Fire Marshal comments
Quiet Cadence Farm
PM-26-00002

Subject: PM-26-00002 Quiet Cadence Farm - Pre-Application Meeting, CDS Planning Notes

This memo refers to the proposed Riding Academy/Agricultural Event Center located at 730 Alford Rd., Northeast of Ellensburg.

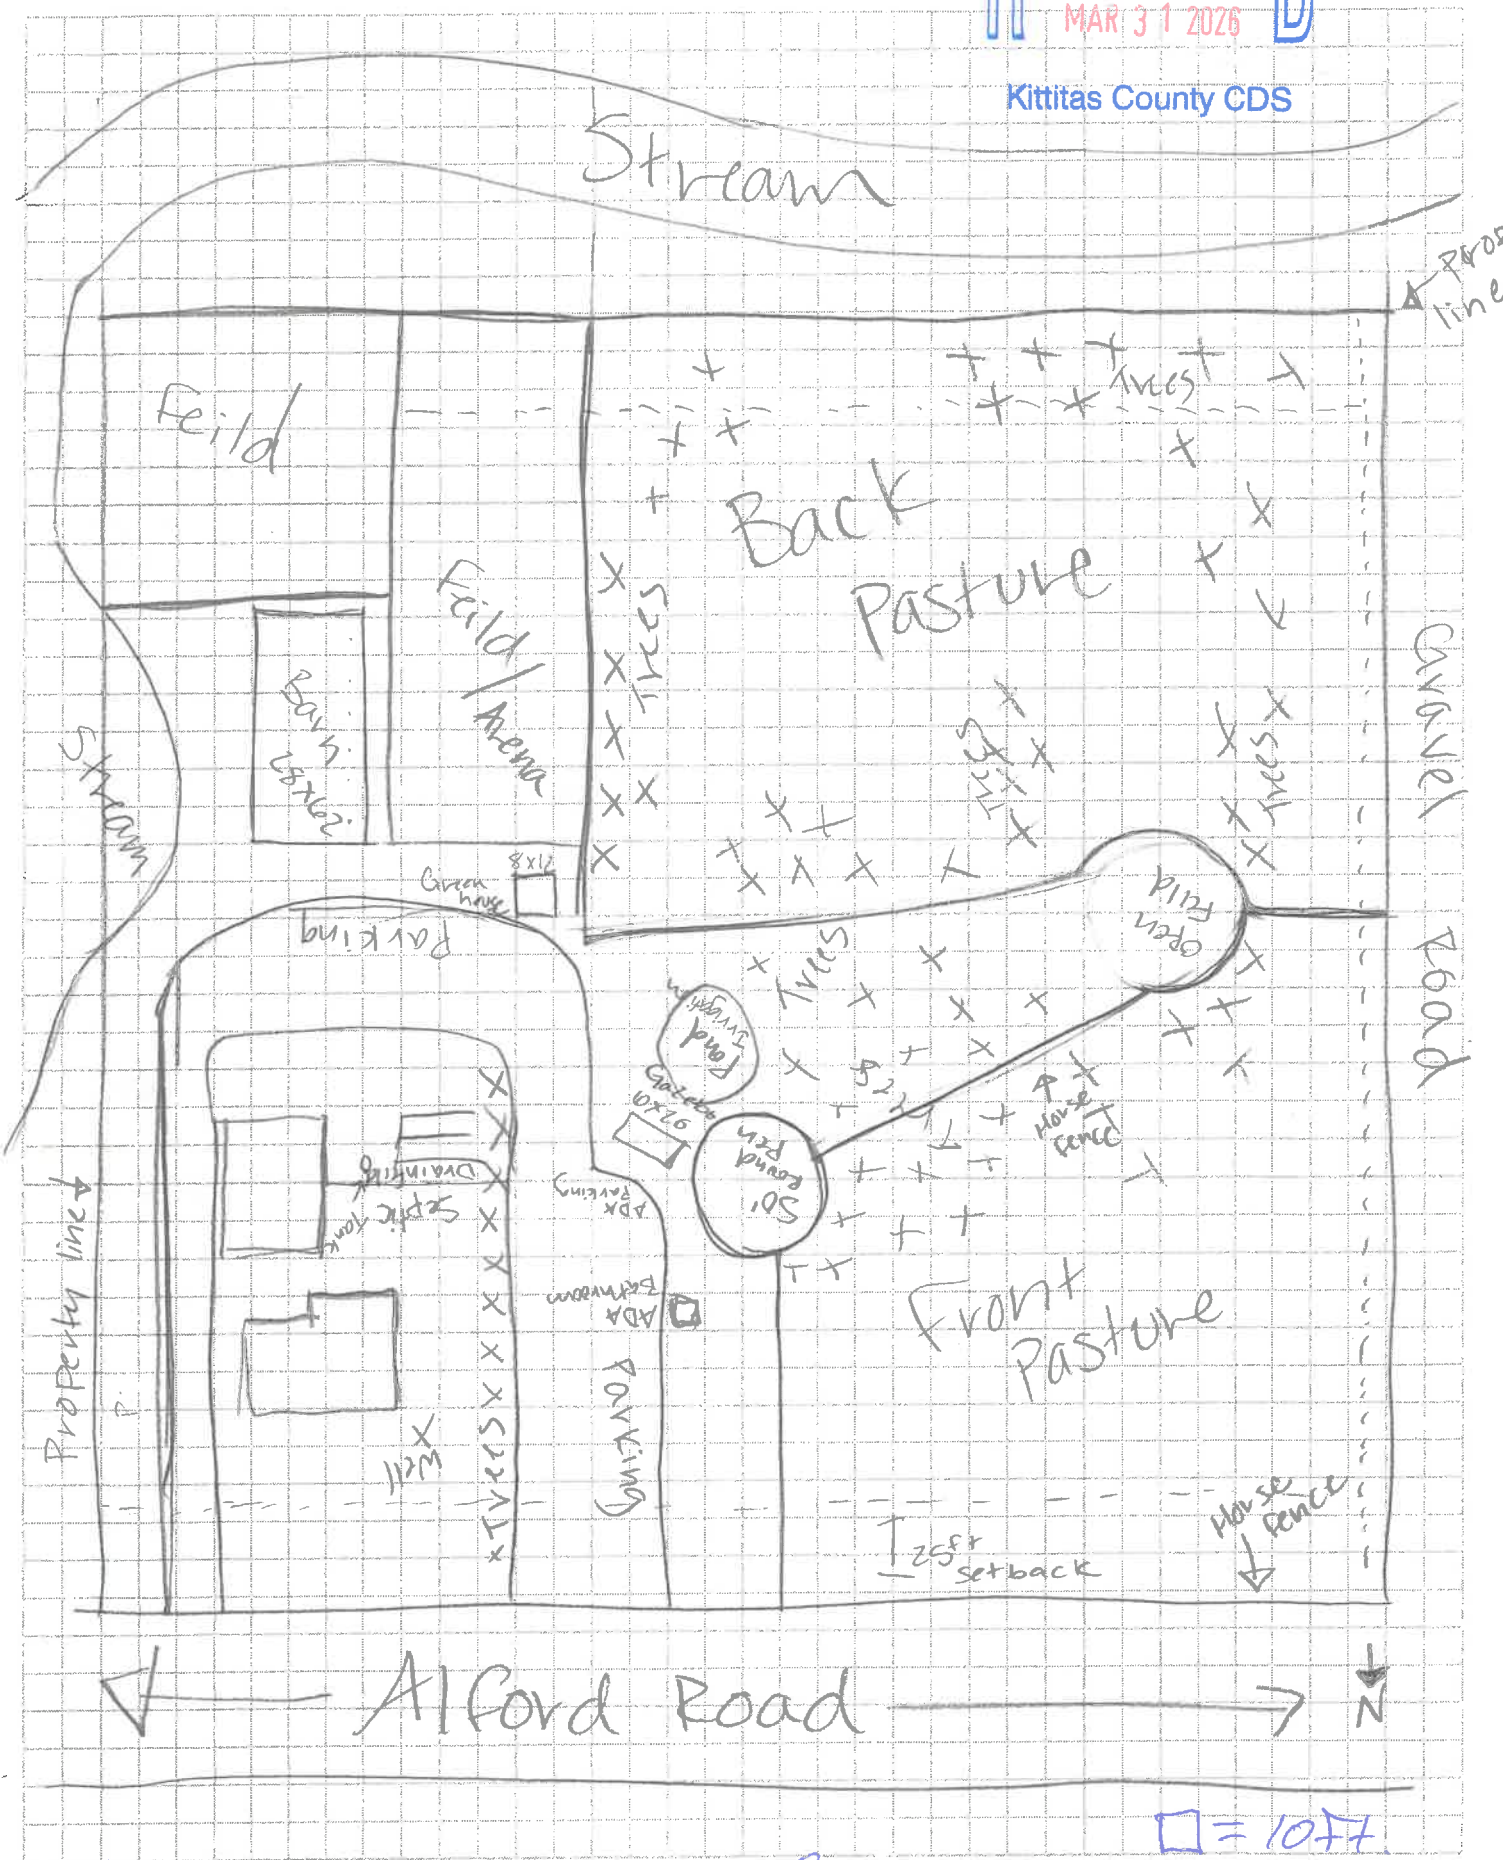
Fire apparatus access is required for this application. The roadways and maneuvering areas as indicated in the application do not adequately provide required fire apparatus access. Provide fire apparatus access roads with an unobstructed width of not less than 20 feet, an unobstructed vertical clearance of not less than 13.5 feet, with an all-weather driving surface and capable of supporting the imposed loads of fire apparatus. Access roads shall extend to within 150 feet of all portions of the facility and all portions of the exterior walls of the first story of the building.

Approved fire apparatus turnarounds are required for this project. The indicated provisions for turning around fire apparatus are not adequate. Provide a turnaround meeting the requirements of the International Fire Code Appendix D.
